CITY OF PORTLAND, MAINE

PLANNING BOARD

July 20th, 2015

Project Name: Jewish Community Center and Preschool/Daycare
Conditional Use and Level III Site Plan
Project #: #2015-058 (Conditional Use and Site Plan)
Address: 1342 Congress Street, Portland
CBL: 191-B016 & 017
Applicant: Jewish Community Alliance of Southern Maine
Planner: Jean Fraser

SCALE: AS SHOWN

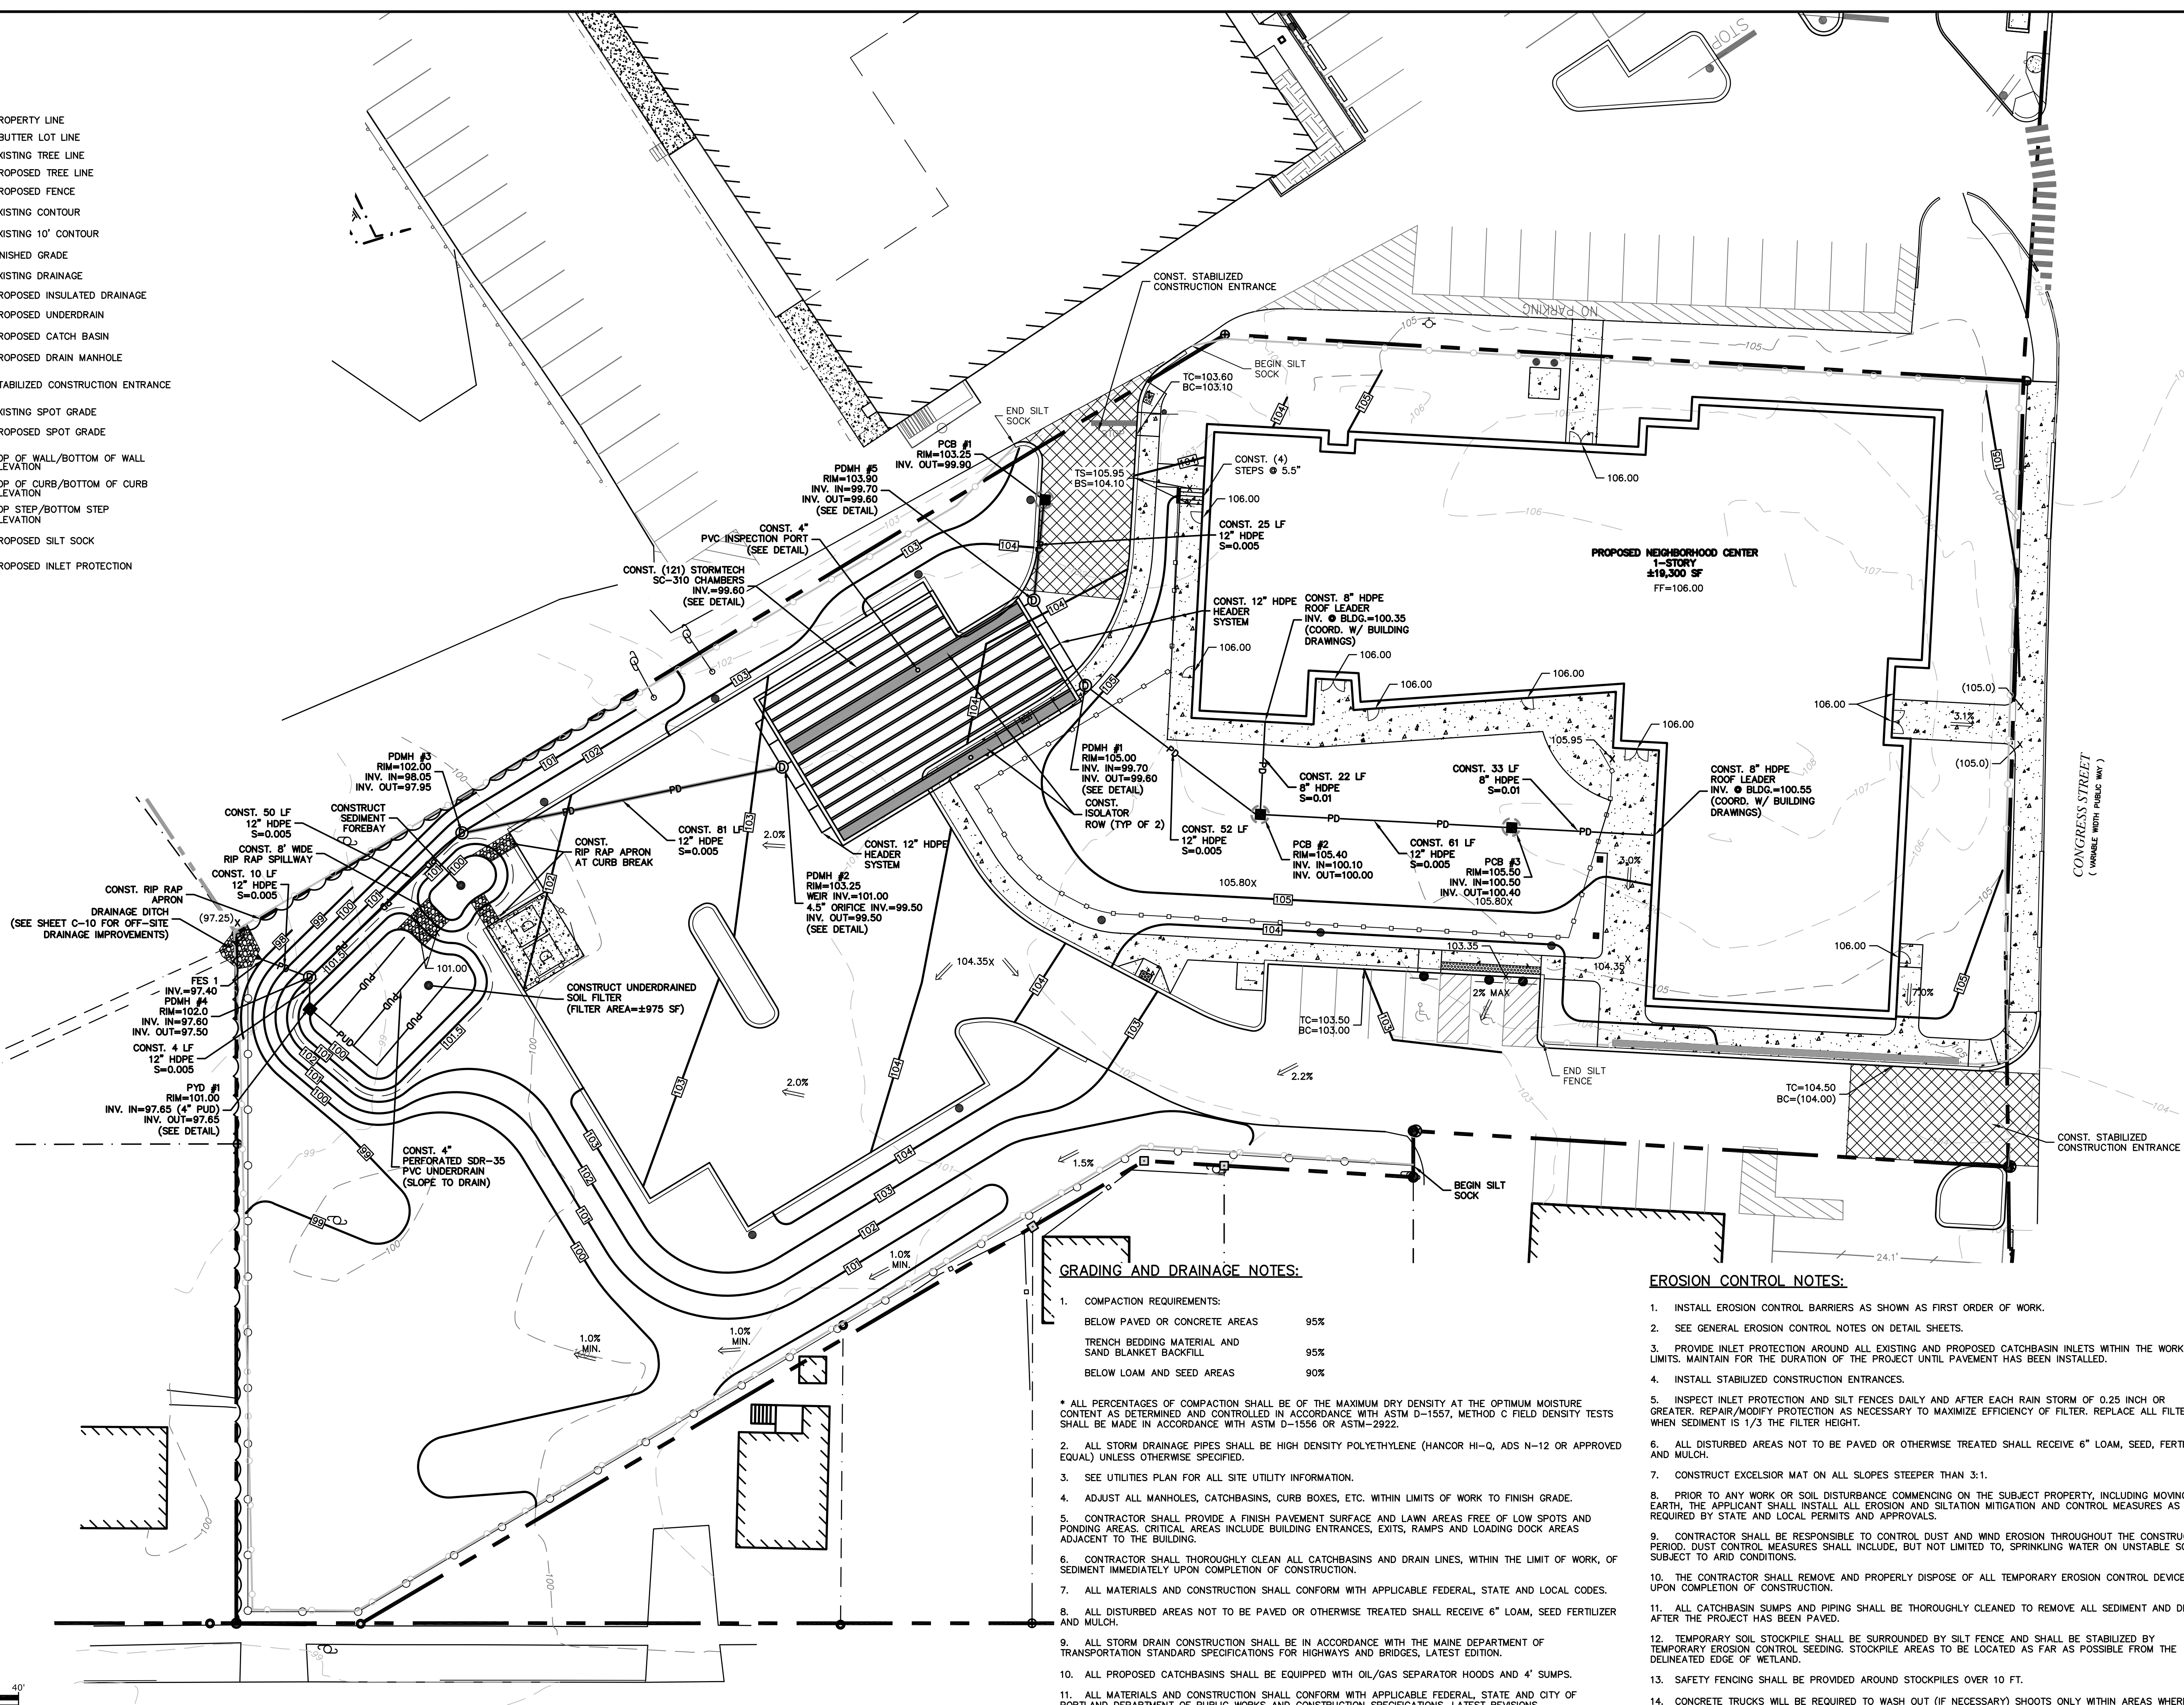
1. **Driveway width:**
The Planning Board voted 6-0 (Morrissette absent) to waive Technical Design Standard Section 1.7.1.3 to allow the proposed driveway to be 22.7 feet wide for one section near Congress Street as shown on the Site Plan in Plan P6;
2. **Soil survey**
The Planning Board voted 6-0 (Morrissette absent) to waive Technical Design Standard Section 7 *Soil Survey Standards* that require a soil survey as the applicant has previously taken soil borings as part of an earlier environmental assessment.

- iii. That the applicant revise the curb ramp layout at Congress Street in accordance with the comments of Tom Errico dated June 26, 2015, with revised plans to be reviewed and approved by the Planning

- iv. That the height of the boundary fence along the eastern boundary and associated buffer treatment be the subject of further discussion with the City Arborist, Planning Authority and nearest neighbor (P Bernard) and any agreed revisions be shown on a revised Site Plan/Landscape Plan for final approval prior to the issuance of a building permit; and

- vi. That additional lighting information shall be submitted in respect of the widened drive access and building entrance nearest to Congress Street to show that the site lighting meets the City Technical Standards, and any deficiencies shall be addressed in a revised lighting plan for review and approval prior to the issuance of a building permit; and

- The driveway entering the site from Congress Street is noted as having a width of 22.7 feet. This width (in the area where parking maneuvers occur) does not meet City standards and thus a formal waiver should be requested by the applicant.

Status: The curb ramp layout should be revised so that the ramp flare does not impact accessibility along the sidewalk route. Having a tip-down design will help to address this issue.

Status: I find the proposed driveway width to be acceptable given that most vehicles will be passenger cars and that a secondary driveway via the Westgate Shopping Center will be provided. I support this waiver request.
